9 March 2015

SSD 6848 LISMORE BASE HOSPITAL REDEVELOPMENT AND NEW CARPARK STAGE 3B

(a) Response to Road & Maritime Services' (RMS) Letter

PLAN
VEHICLE B99 - ENTRY FROM URALBA STREET
SCALE 1:100

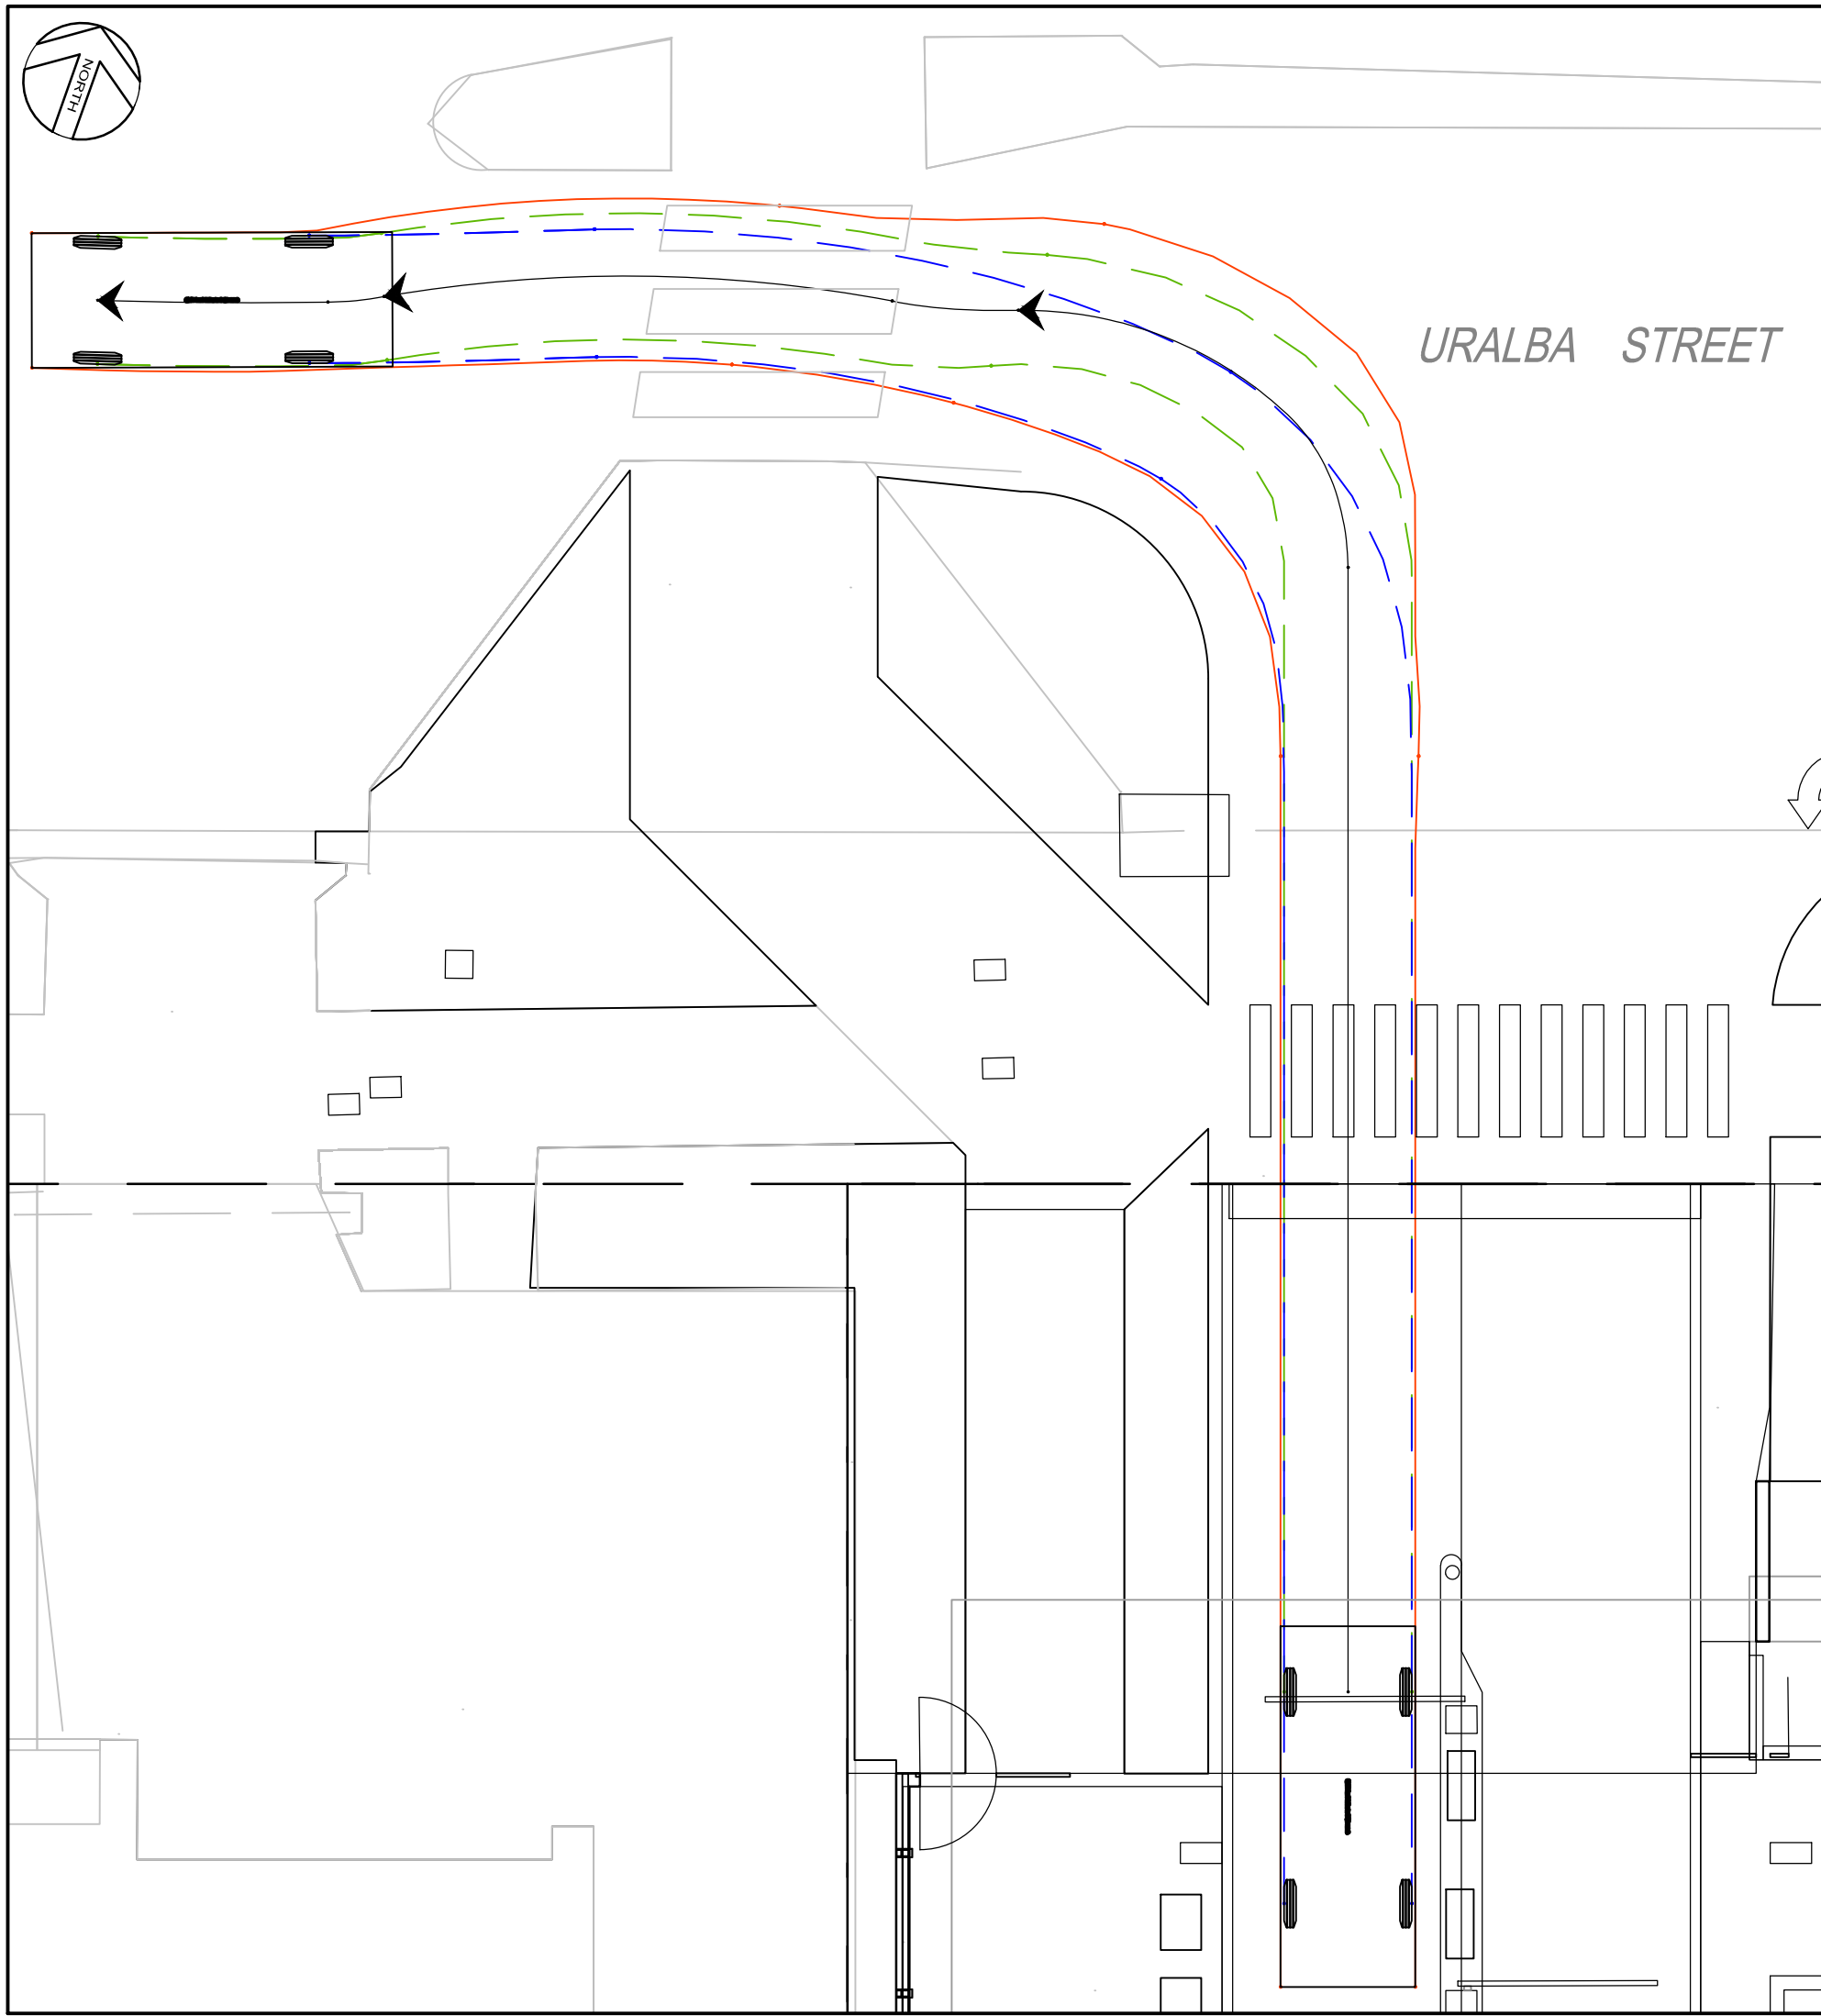
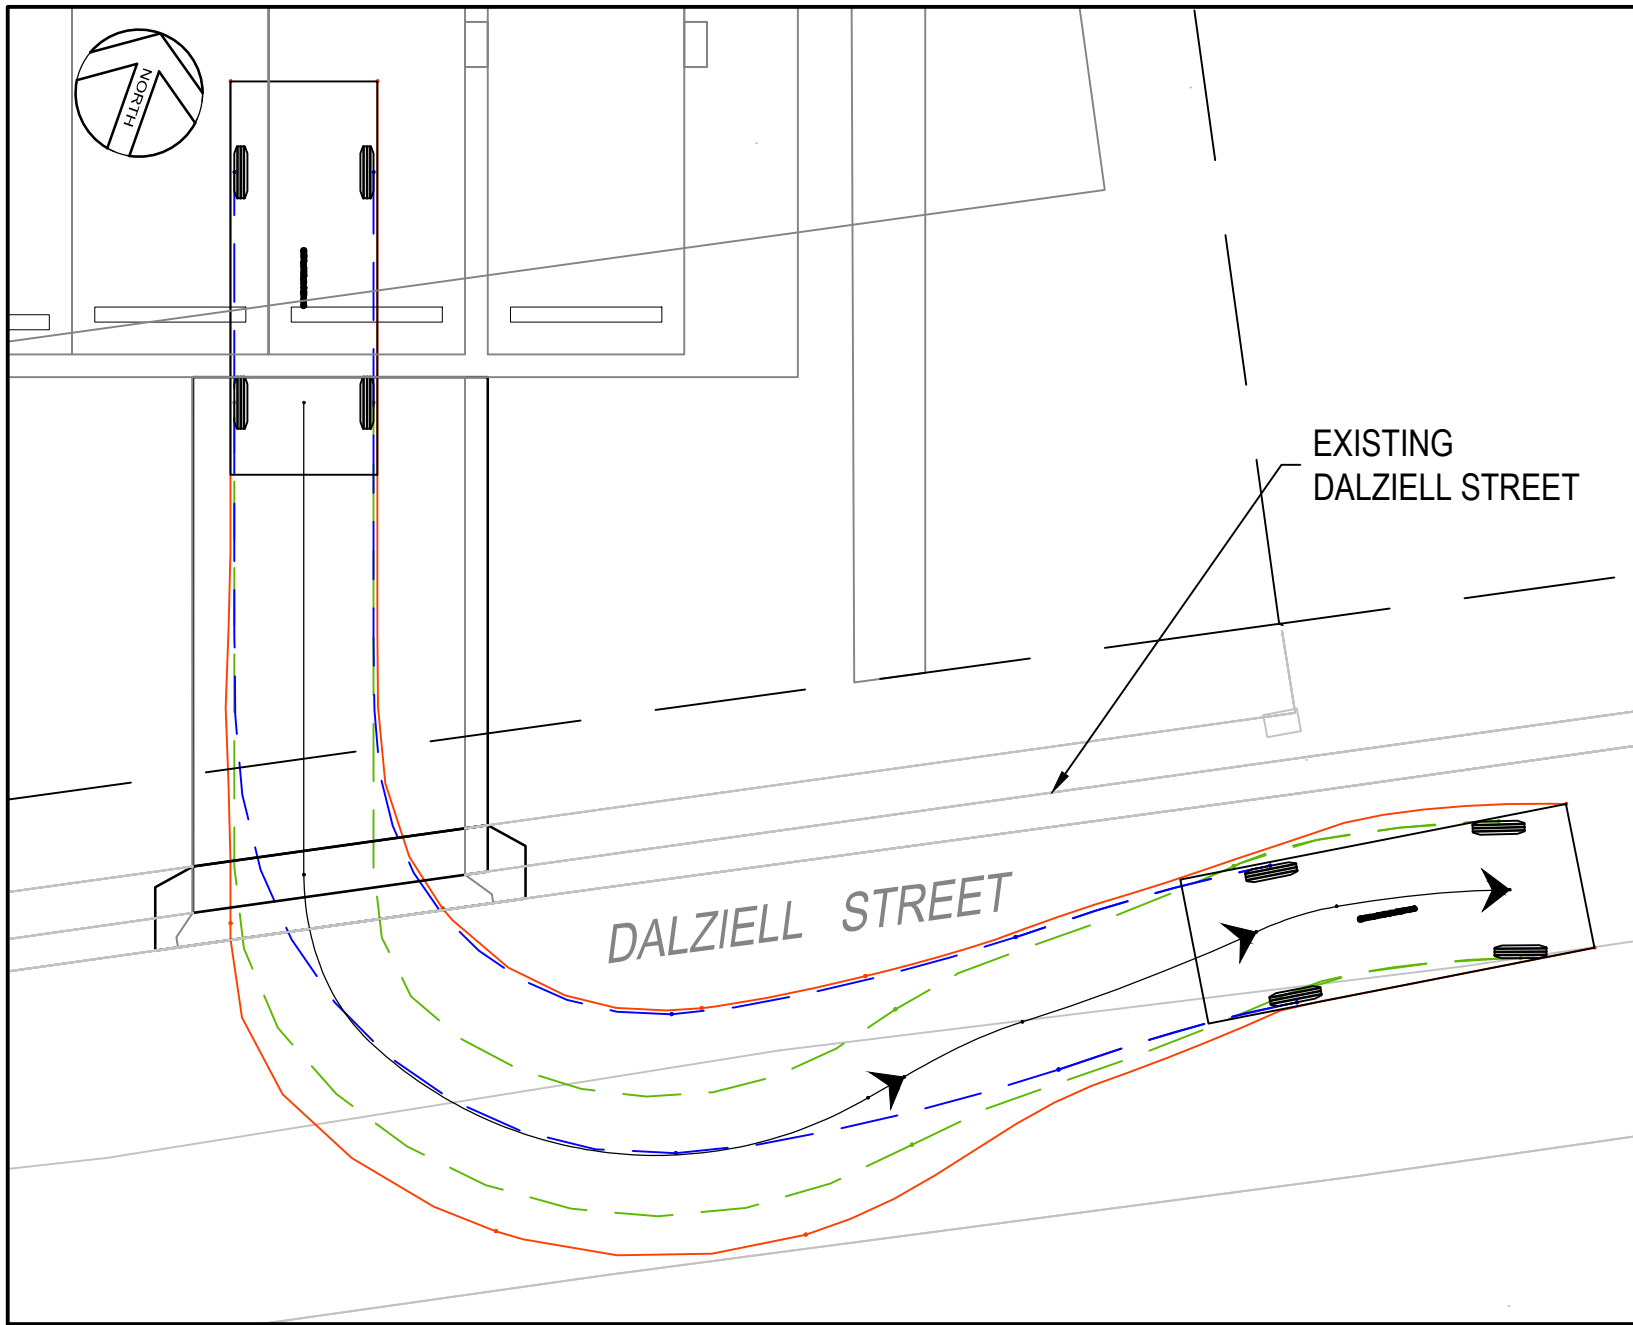
Item 3: The current design allows all vehicular movements onto Uralba Street to be carried out in a forward direction.
